DECISION DELEGATED TO HEAD OF PLANNING

Application No:	H18-0748-26	Applicant:	Ms K Dayton
Proposal:	Conversion and partial reconstruction of existing barn into two dwellings		
Location:	Wingland Farm Gunthorpe Road Walpole St Andrew		
Terminal Date:	6th October 2026

Front Elevation (S)
Scale: 1:100

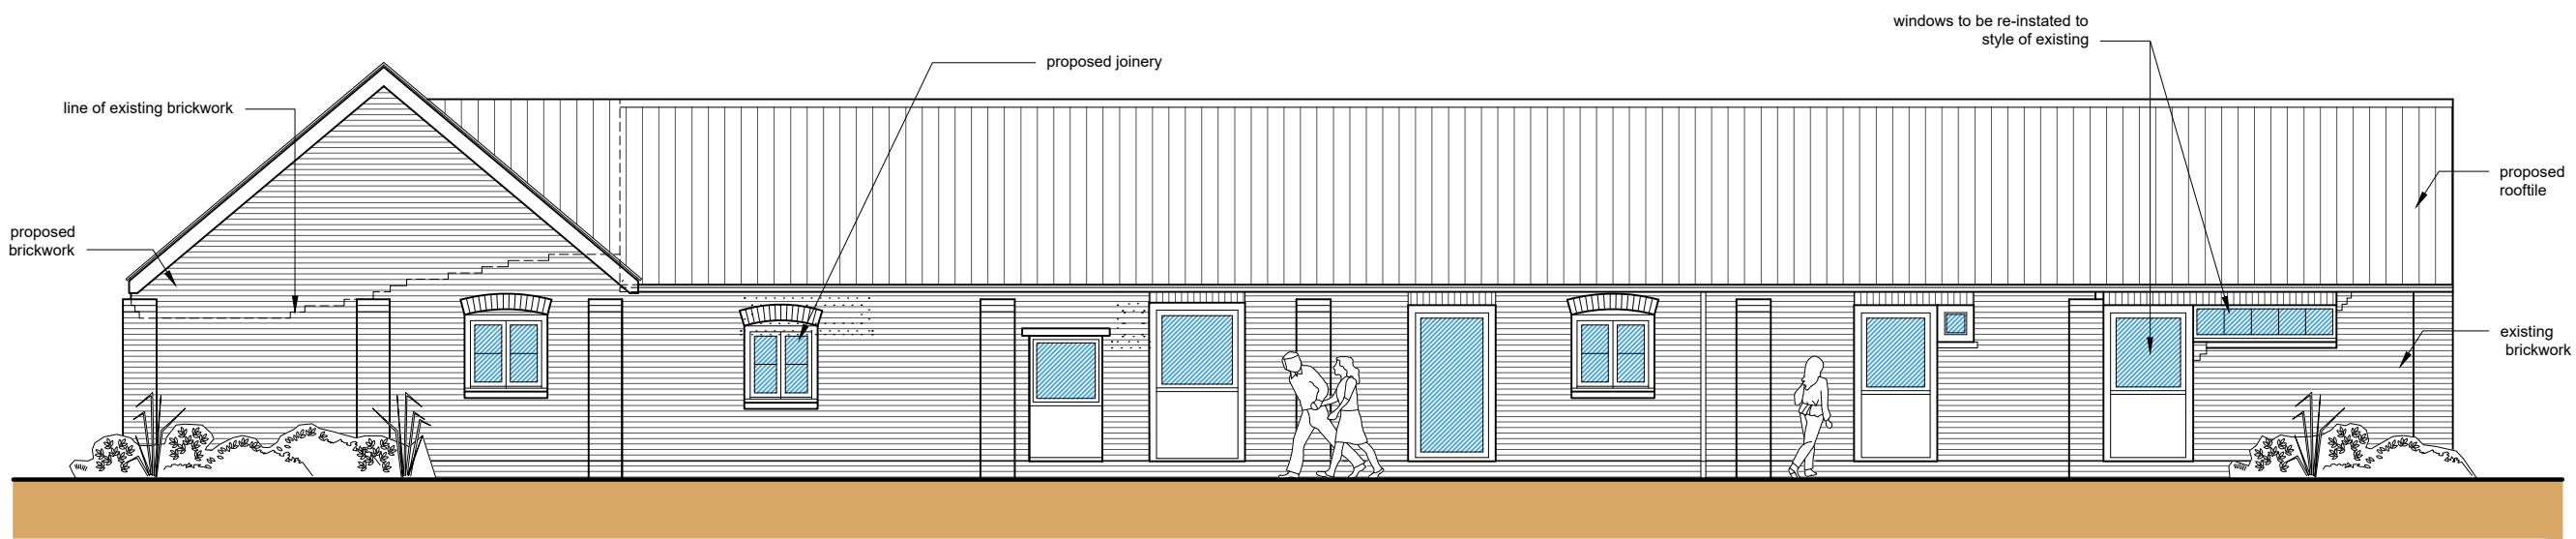
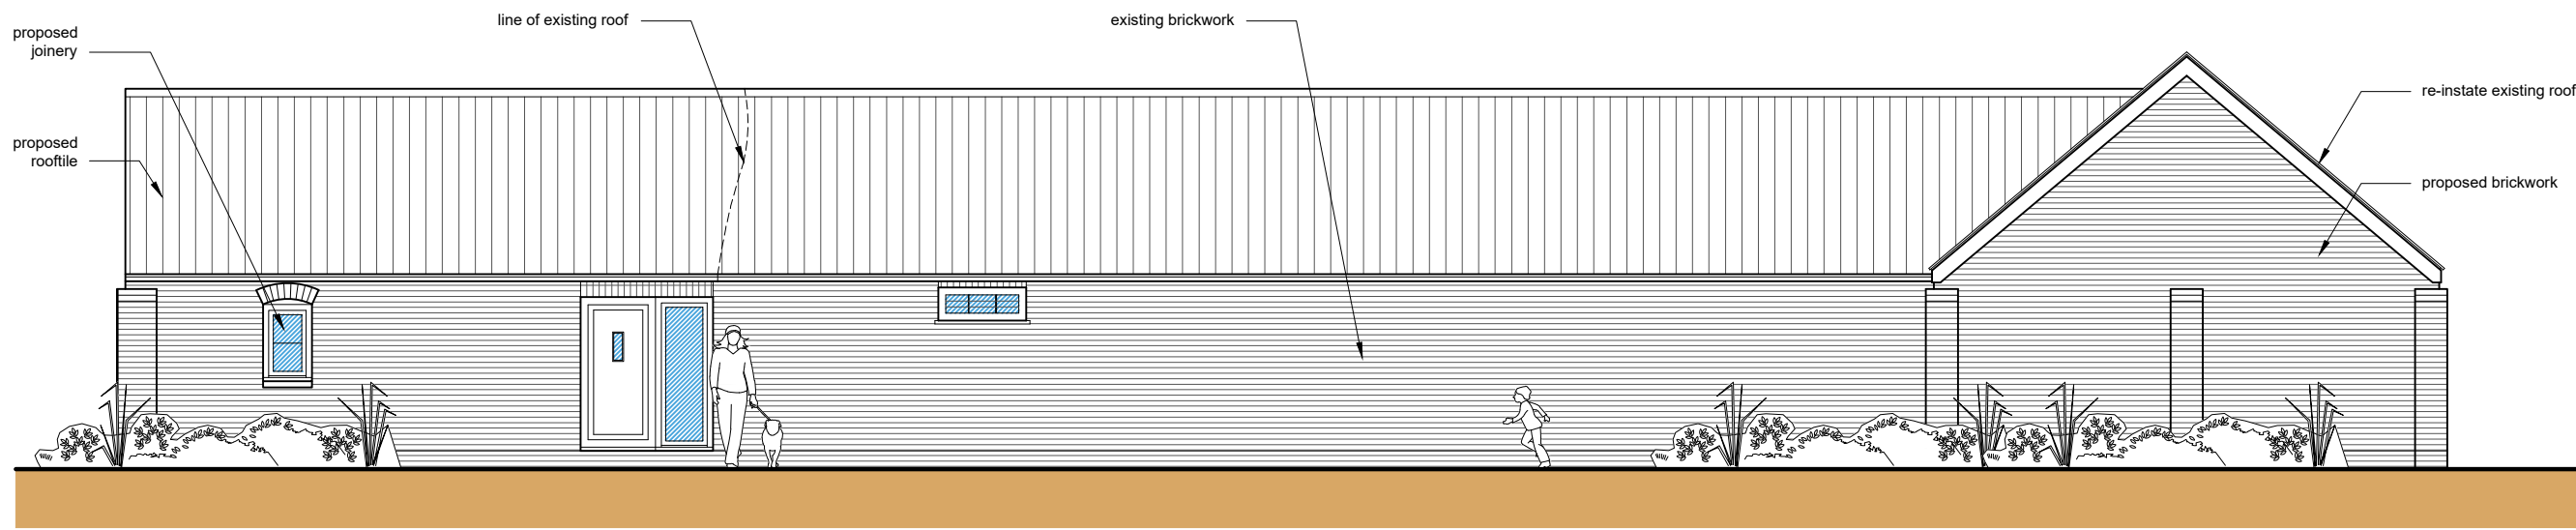
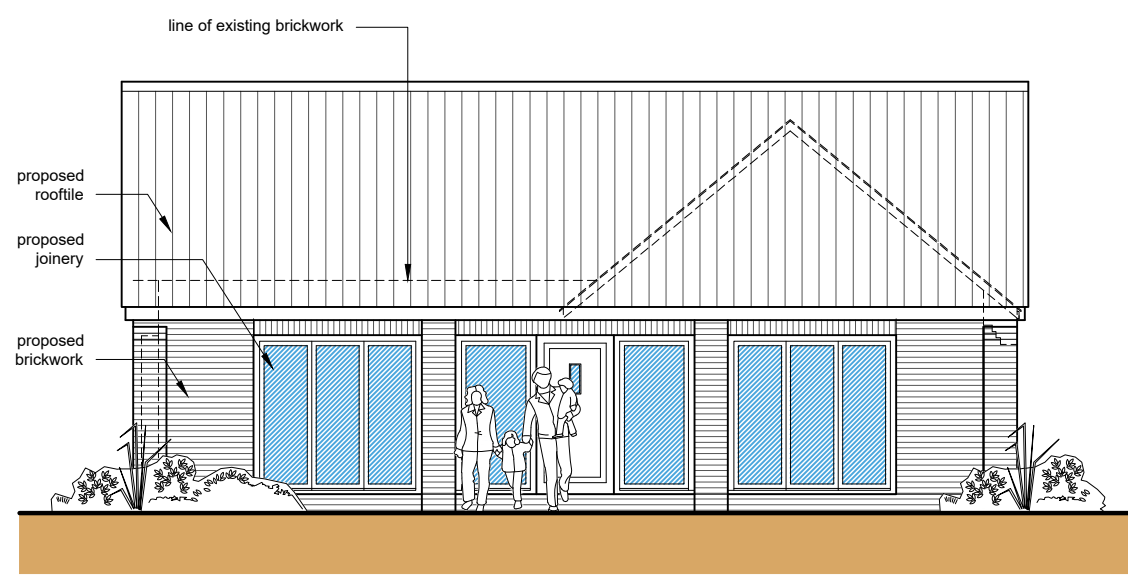
The existing building is of such poor quality that the proposal would be enhancement, as the site would be neatened by the proposal. That being said, the building is of such poor quality that the full extent of works cannot necessarily be judged by the drawings shown, and therefore, the extent of works may create a divorce between existing and proposed which is damaging to the rural area. Moreover, the finished appearance would be dependant upon the quality of the brick match selected, as without a suitable match, there would be a clear patchwork effect, damaging to the

Existing openings have been largely maintained. Window detailing is good and the doors illustrated are reminiscent of stable doors. There is therefore a clear appreciation of the existing building, which lends itself positively to the final design. That being said, from the details provided, whilst the openings are retained, the doors and windows themselves would not be, creating a further separation to the previous use of the building.

Floor Plan
Scale: 1:100

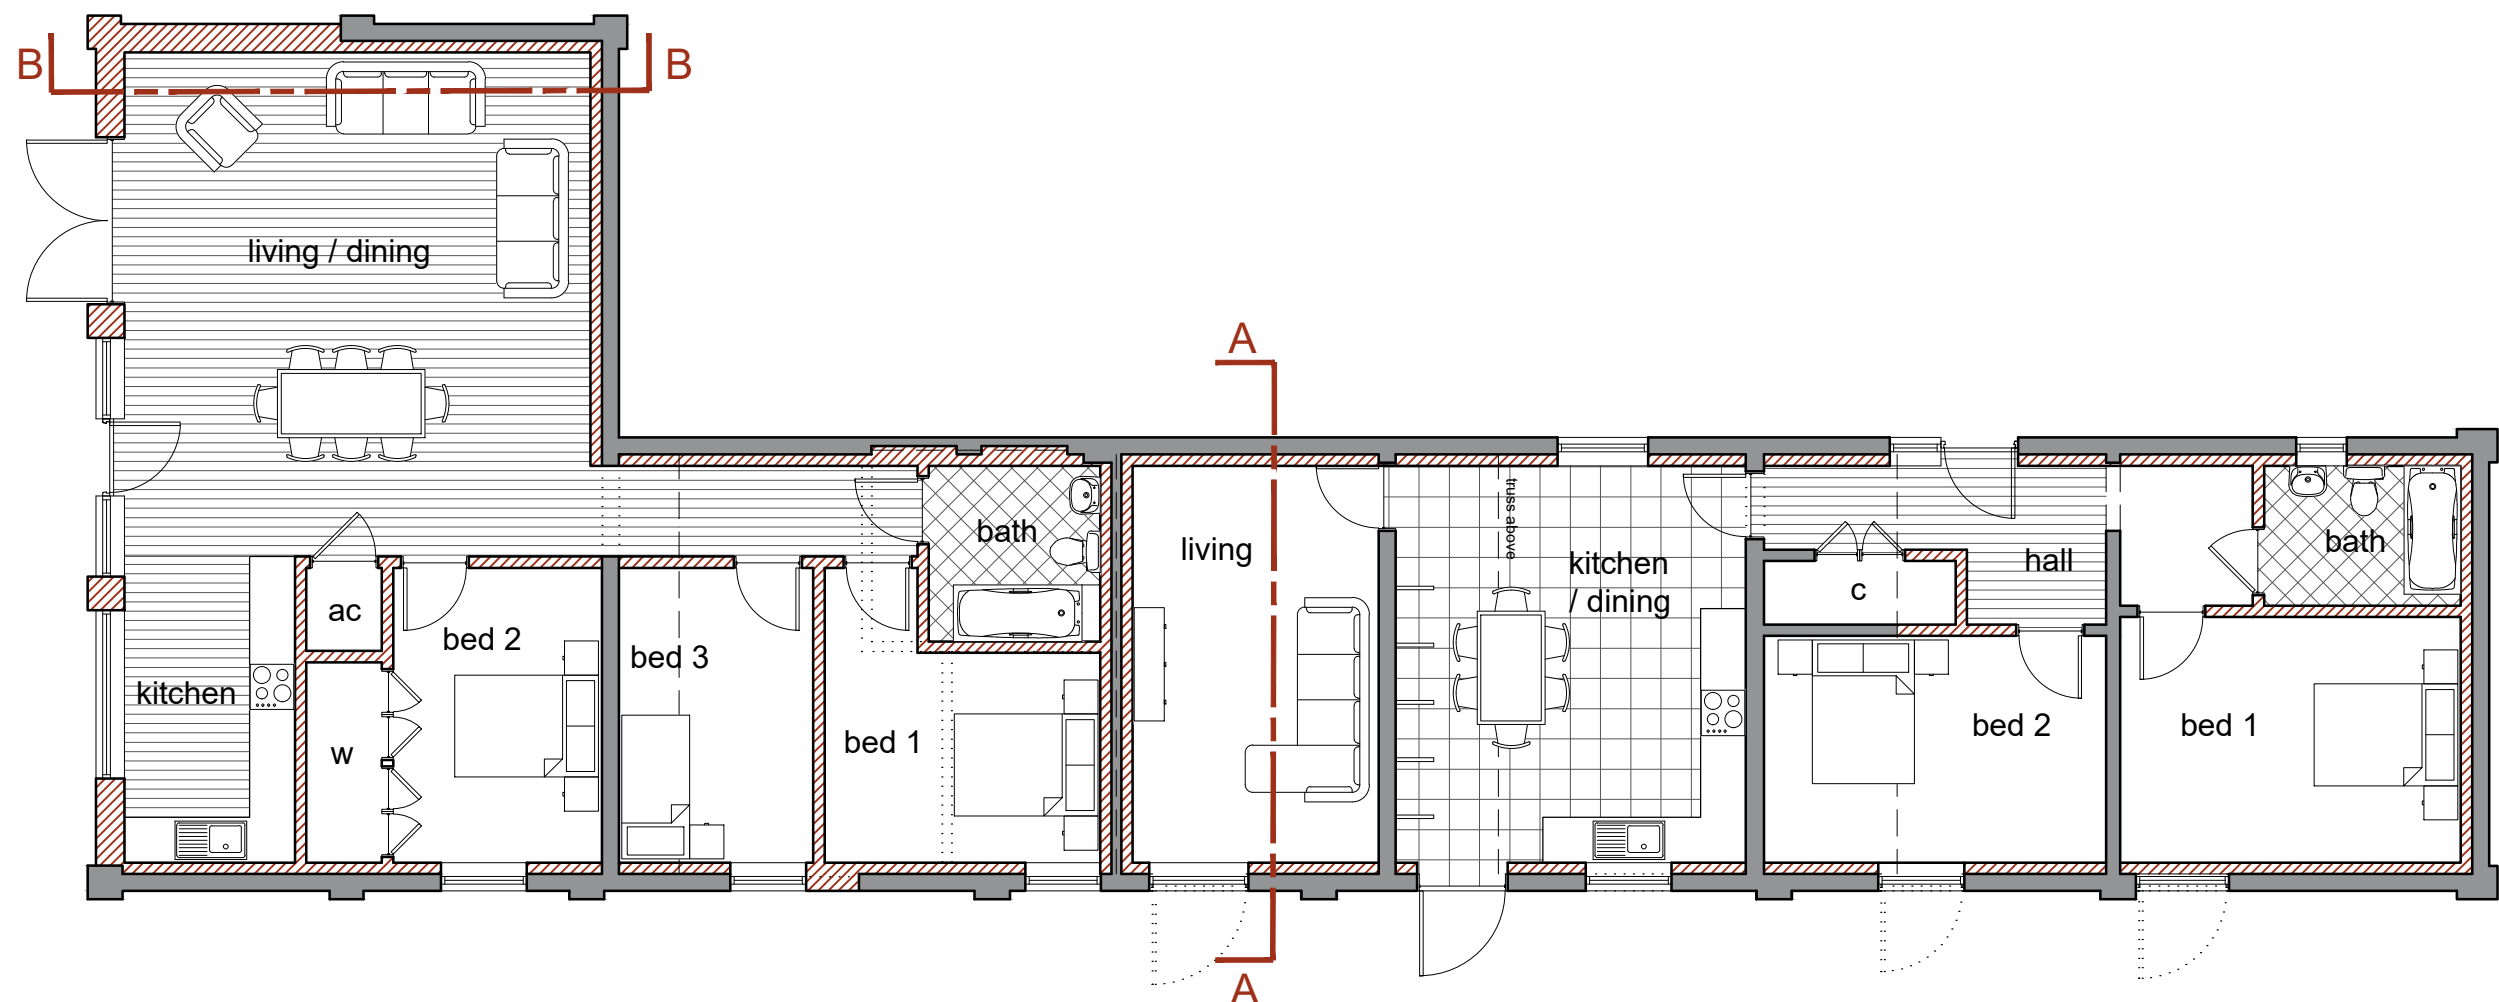
1. Whilst the provided structural survey is noted, the building is evidently not capable of conversion without significant alterations and rebuild needed. Approximately half of Plot 1 and three-quarters of Plot 2 have no roof. The remaining roof has failed in large areas. The walls of the "open structure" (as labelled on drawing no P100) have collapsed in places and are incomplete. The westernmost block is shown on the structural survey as collapsed and covered in foliage. Other sections have been unable to be surveyed properly by the conductor of the structural survey due to the levels of manure in the buildings.

Beyond the structural issues, the proposal incorporates what is in essence an extension to the eastern side through the enclosure of an entirely collapsed section of the structure. This extension is considered to be significant in its own right.
